The North Wales Wind Farms Connection Project

SP Manweb's Response to Late Deadline 1
and Deadline 3 Representation from Eifion
Bibby relating to Requests for Relocation
of Poles

Application Reference: EN020014

Deadline 4 Submission

SITE PLAN 2

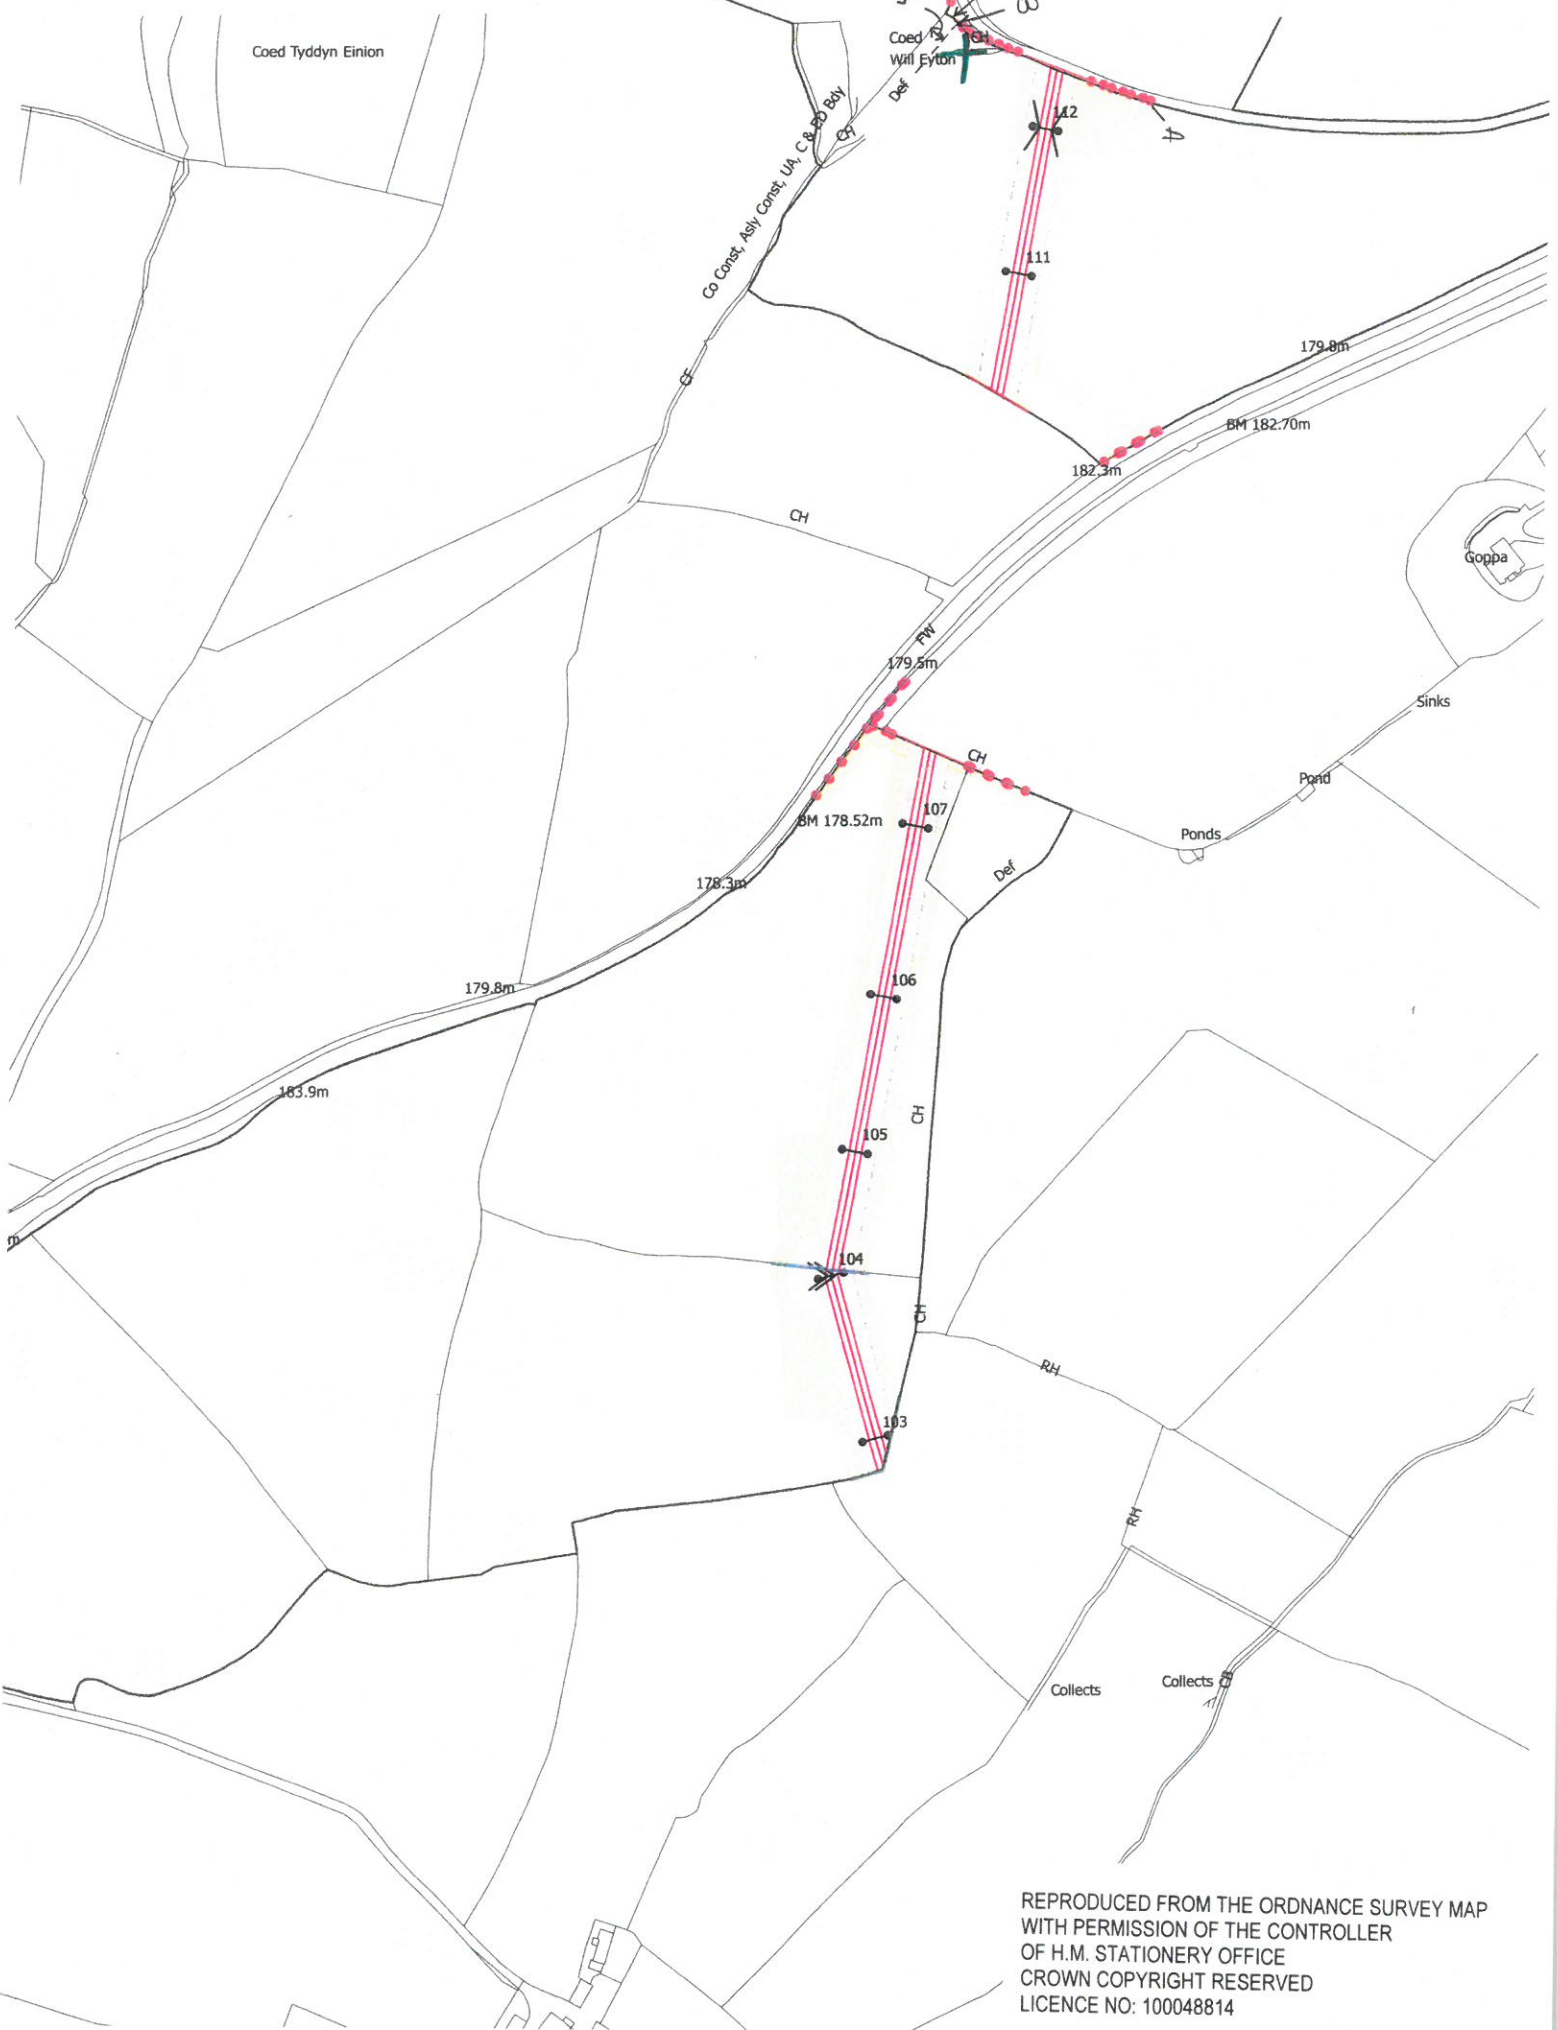
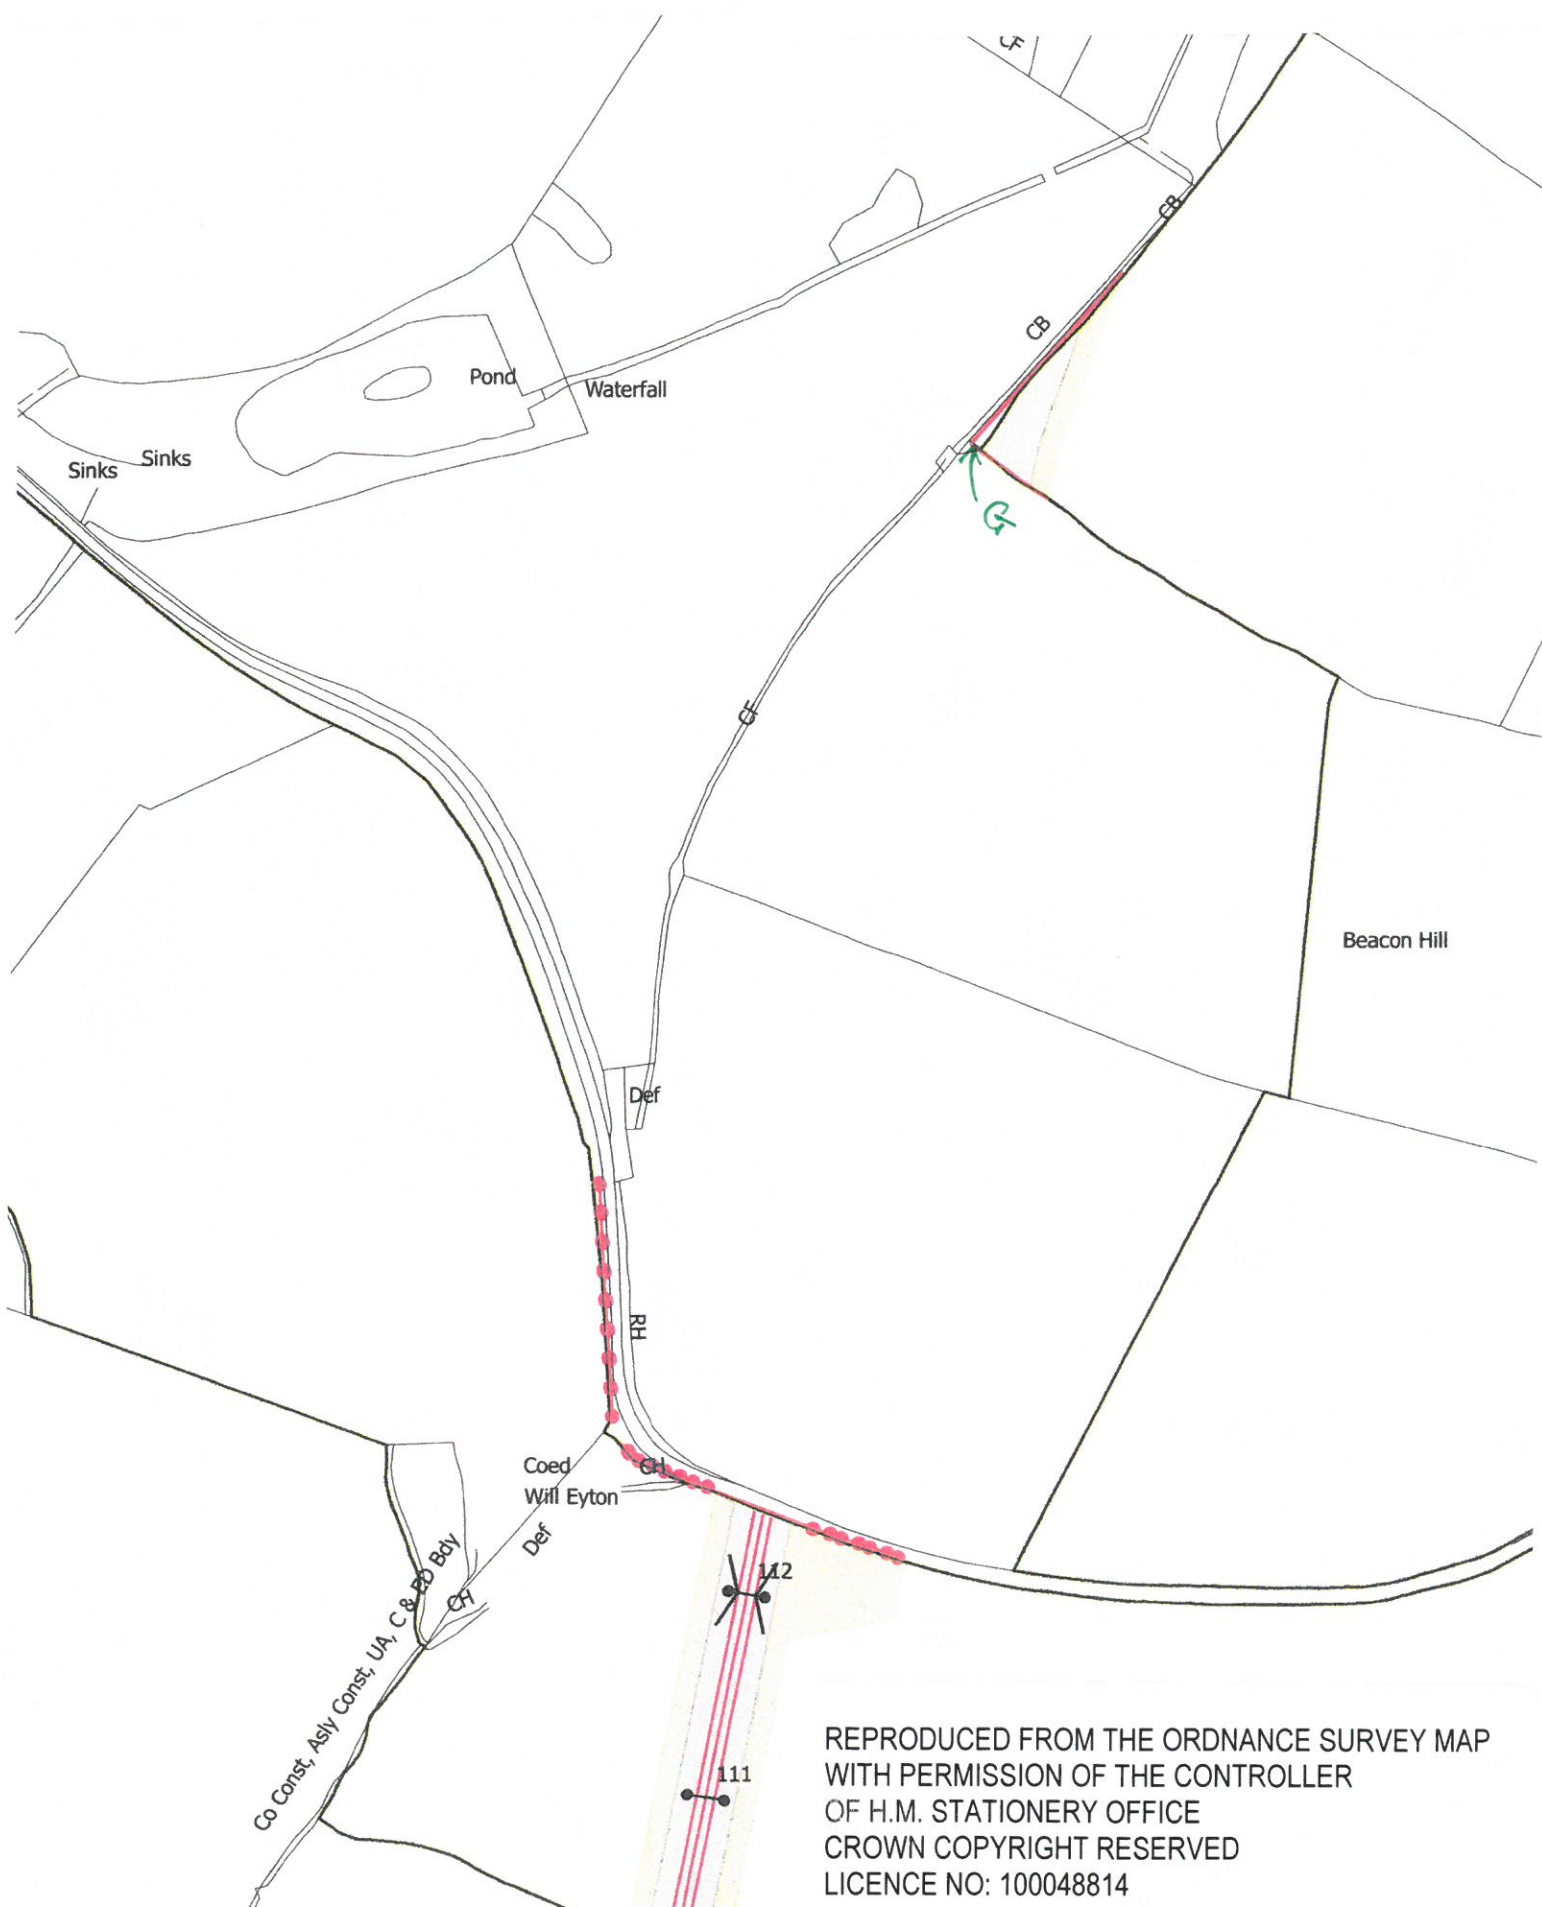
Respondent	Written Representation	SPM response
	<p>land)as approximately shown in green by “x” on appended Site Plan 1.</p> <p>2. that the existing field gateway as approximately shown in green by “ G” on attached Site Plan 2 will not be obstructed by proposed poles 117.</p>	<p>Manweb’s representative has notified Mr Bibby of the changes that may be possible and is currently awaiting a response on this matter. If Mr Hughes would prefer this option SP Manweb is able to incorporate the change in to either Option A or B as it is within the LoD.</p> <p>2. Should pole 117 interfere with the gate as identified by Mr Bibby at point 2, SP Manweb is happy to consider repositioning the gateway to a mutually convenient location as this would be within the LoD.</p> <p>The offer (at point 1 & 2) has been put in a without prejudice offer to Messrs Hughes and their agent for consideration. On the 23/10/2015, a further email was also sent to Mr Bibby confirming that SP Manweb was not able to move the poles any further in the direction of pole 113 due to technical constraints.</p>

Respondent	Written Representation	SPM response
	<p>winter, along significant sections of the intended route corridor] , the interested party is seeking that poles 119 is moved as far to the west of the adjacent field boundary fence as possible , as the current proposed position would dangerously impede on a narrow corridor available during, in particular, winter months for access with farm vehicles extending from the south to the north of the subject agricultural land.</p> <p>ii) a proposal for re-alignment between Poles 120-123 (inclusive) so as to reduce the number of stays required to reduce impact on the use and productivity of the agricultural land.</p> <p>iii) that the existing field gateway will not be obstructed by proposed poles 117.</p>
